Ribble Valley Borough Council
Housing & Development Control

Your ref: 3/2023/0384
Our ref: D3.2023.0384
Date: 12th April 2024

Application no: **3/2023/0384**

Proposal: **Proposed new 4 bedroom dwelling and creation of new access on land to the side of 3 Grindleton View.**

Proposed Visibility Splay Plan
Scale (1 : 500)

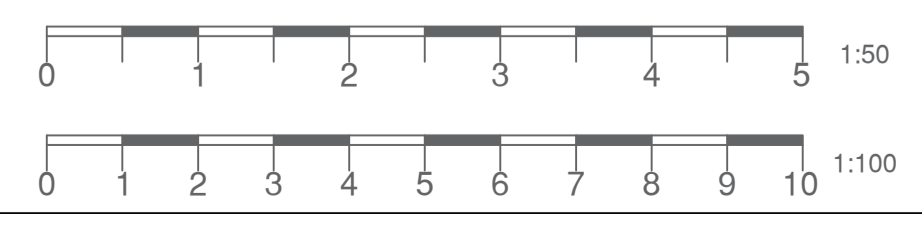
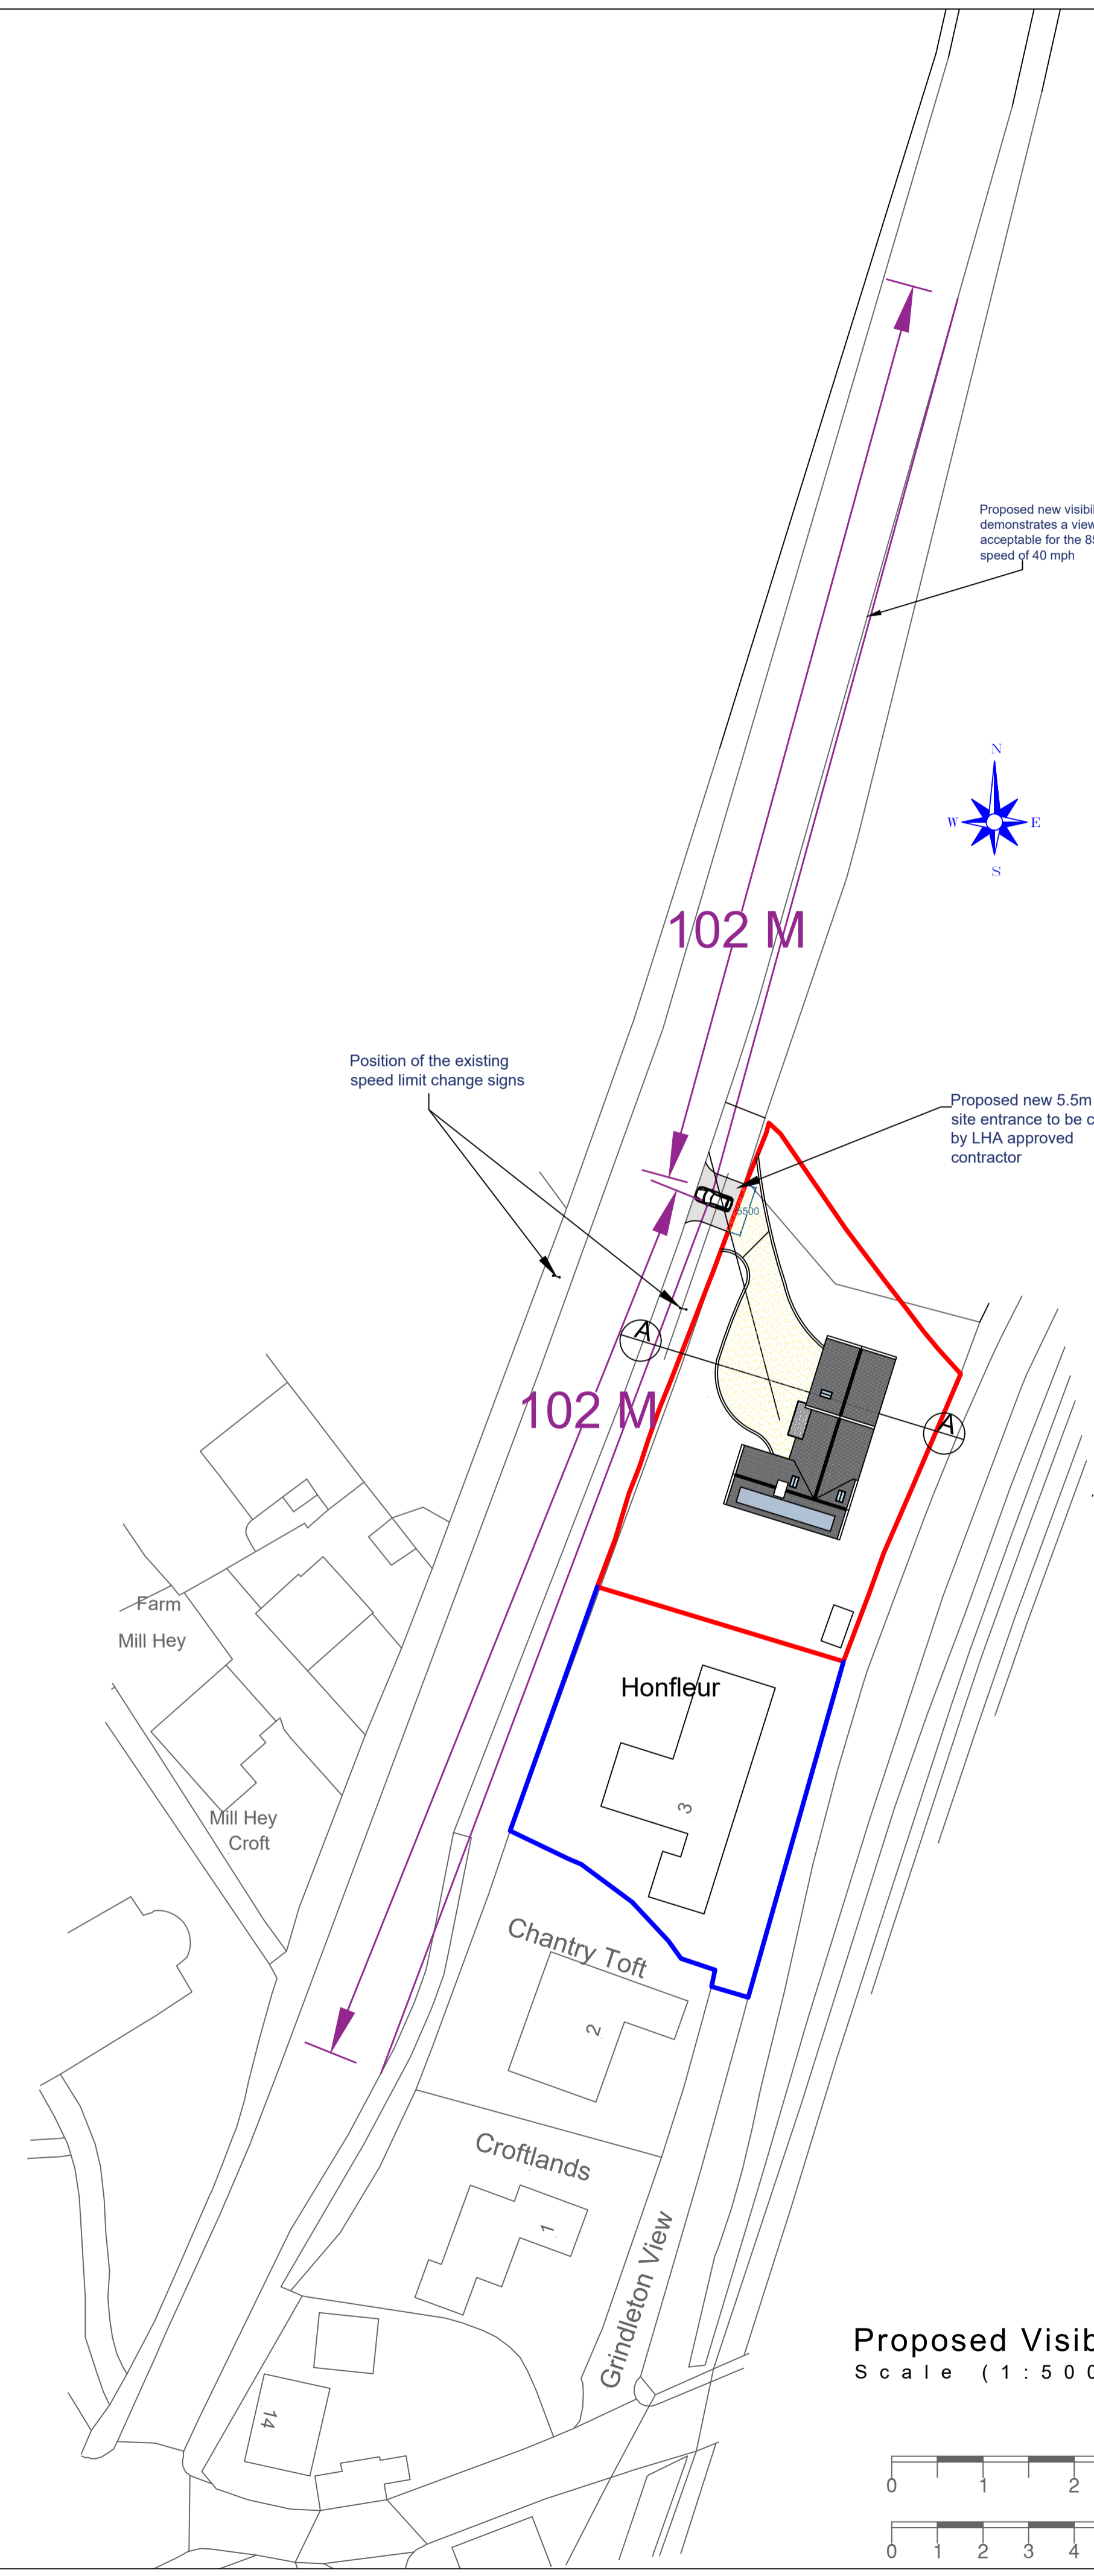
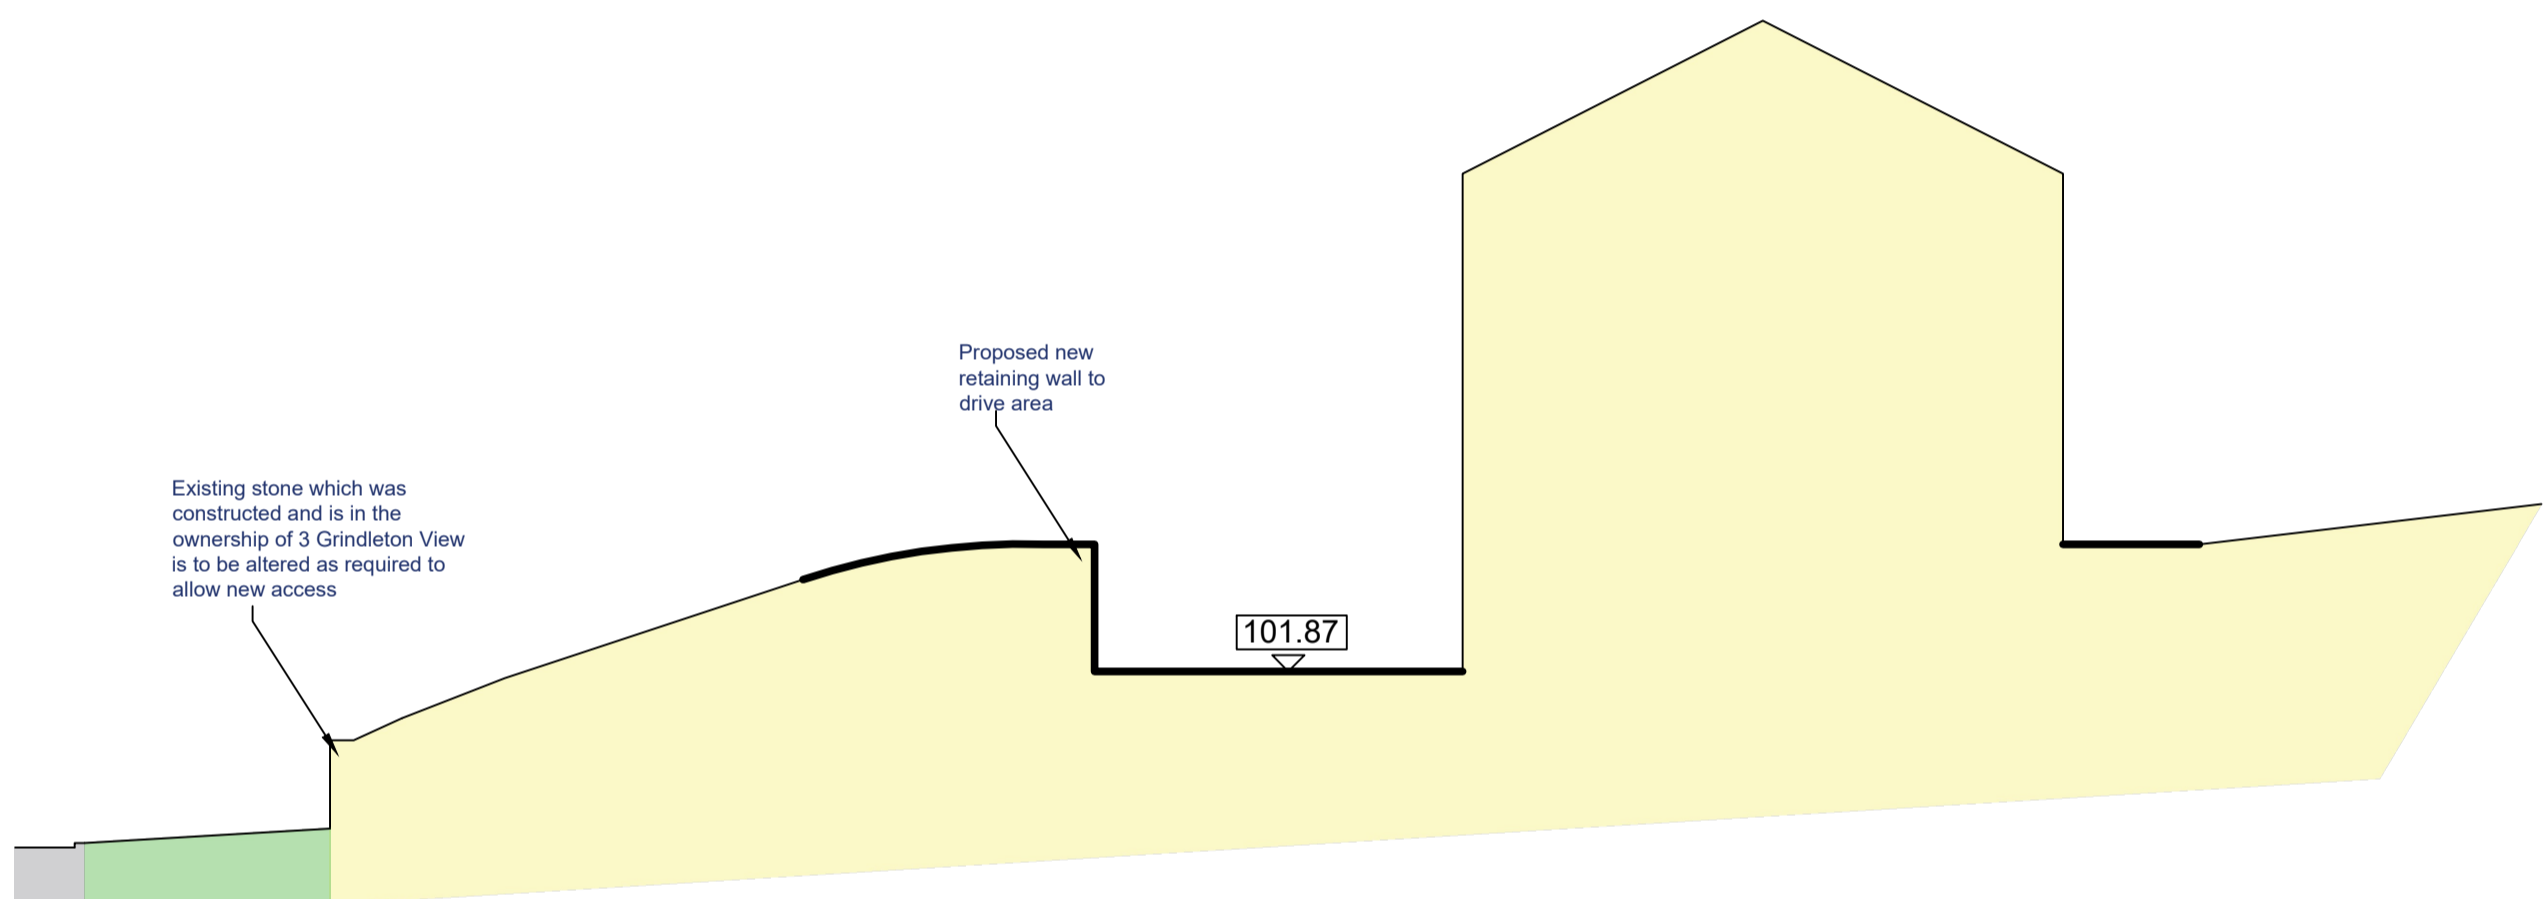
The LHA have reviewed Holden drawing number 004 Rev C titled "Proposed Plan" and note that a new site access will be provided off Sawley Road. The new access will be a minimum of 5.5m wide which complies with the LHAs guidance when serving one dwelling.

However, the LHA will require tie-in details for the driveway and the access to be submitted prior to commencement. This is because currently the LHA are unsure how the driveway will connect to the access, with the driveway being approximately 11.5m wide as it connects to the 5.5m wide access. Therefore, to ensure that the access is not overrun, suitable boundary treatments need to be provided as the driveway connects to the access.

The LHA have further reviewed the drawing and are aware that the access can provide visibility splays of 2m x 102m in both directions. The LHA are satisfied with the provided visibility splays since a traffic survey has been conducted which found that 85th percentile speeds along Sawley Road were 40.7mph northeastbound and 38.3mph southwestbound. Therefore, the LHA have no further comments to make regarding the provided splays.

To ensure that the visibility splay to the north of the site access remains clear of any obstructions higher than 1m, the LHA will request that anything within the highway verge in this location is cleared as part of the Section 278 Agreement which will be needed to create the site access.

6. No development shall take place until details of a boundary treatment scheme enabling the driveway to tie-in to the approved site access have been submitted to, and approved in writing by, the local planning authority in consultation with the highway authority.

7. No part of the development hereby permitted shall be occupied until such time as vehicular visibility splays of 2.4 metres by 102 metres have been provided at the site access. These shall thereafter be permanently maintained with nothing within those splays higher than 1 metres above the level of the adjacent footway/verge/highway.

Proposed Site Plan
Scale (1:500)

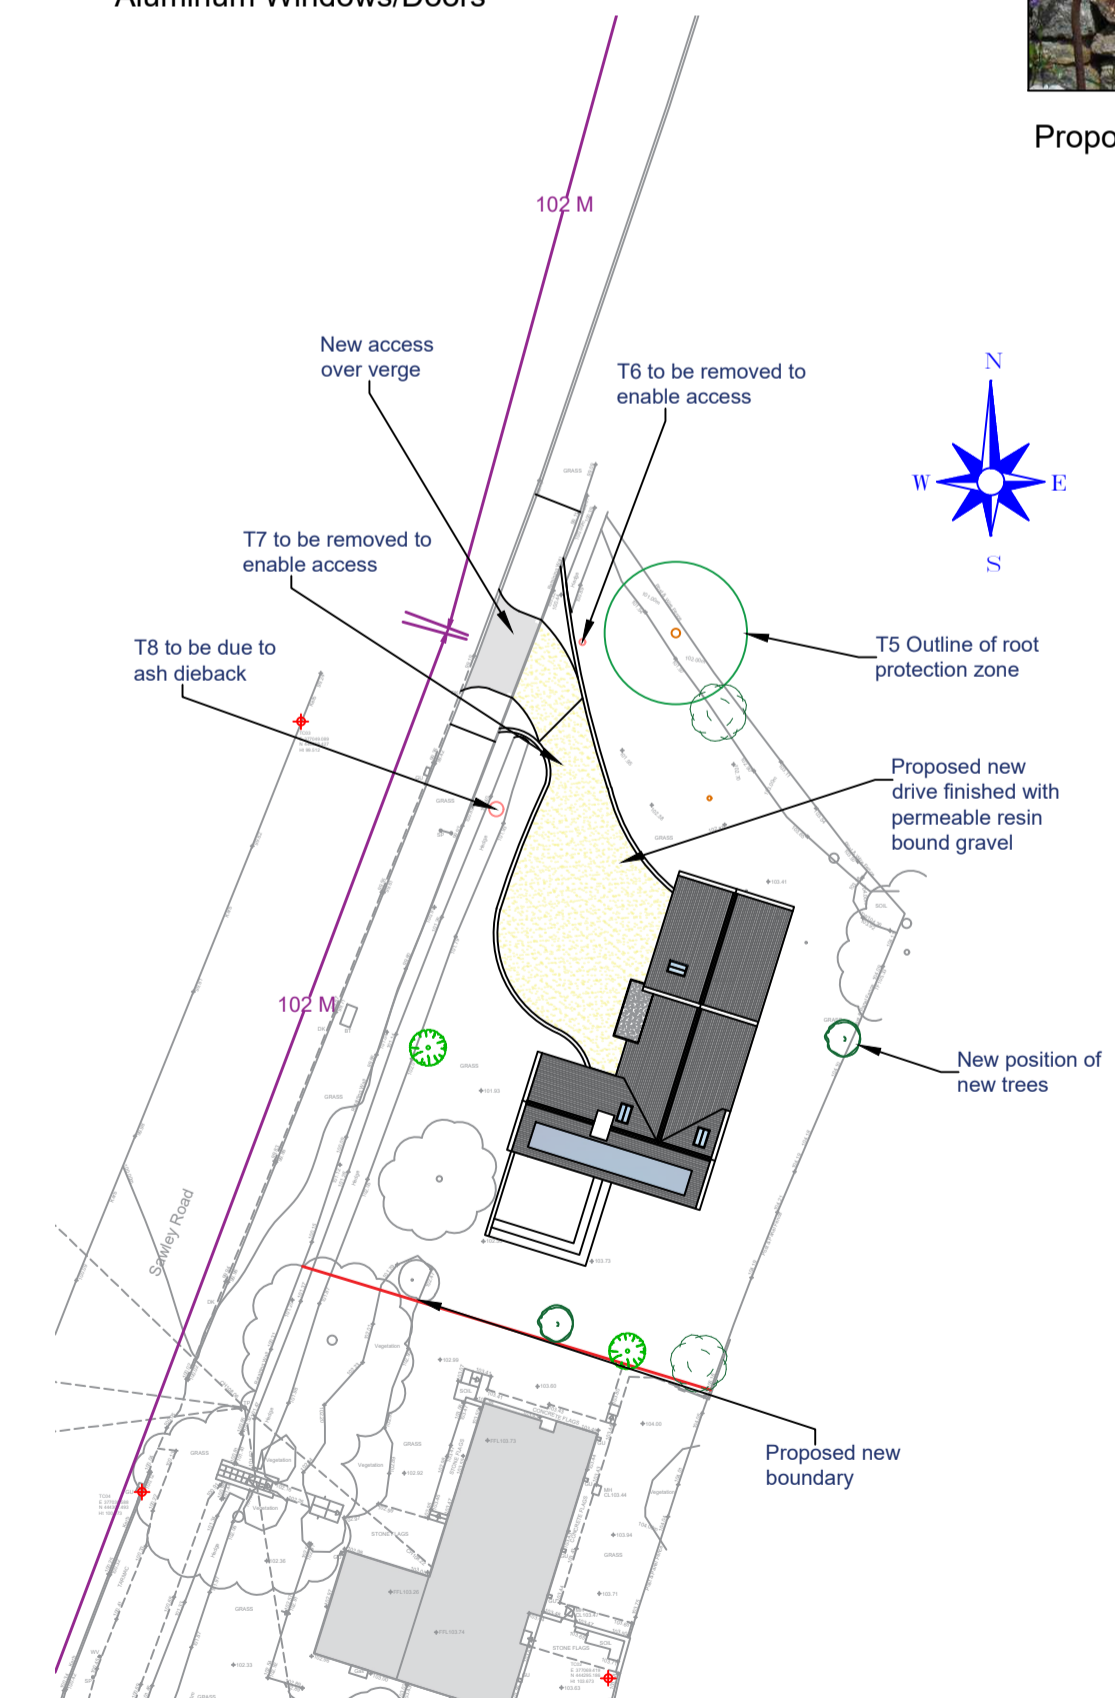
The LHA have reviewed Holden drawing number 003 Rev B titled "Proposed Plan" and are aware that the parking arrangements complies with the LHAs parking guidance as defined within the Joint Lancashire Structure Plan.

The LHA remind the Agent that a minimum of one car parking space will need to have access to an electric vehicle charging point and some form of cycle storage provision for the occupants of the dwelling will need to be provided.

11. Prior to the first occupation the dwelling shall have an electric vehicle charging point. Charge points must have a minimum power rating output of 7kW, be fitted with a universal socket that can charge all types of electric vehicle currently.

12. No building or use hereby permitted shall be occupied or the use commenced until a cycle storage plan for the dwelling has been submitted to the Local Planning Authority, in consultation with the Local Highway Authority. These cycle facilities shall thereafter be kept free of obstruction and available for the parking of bicycles only at all times.
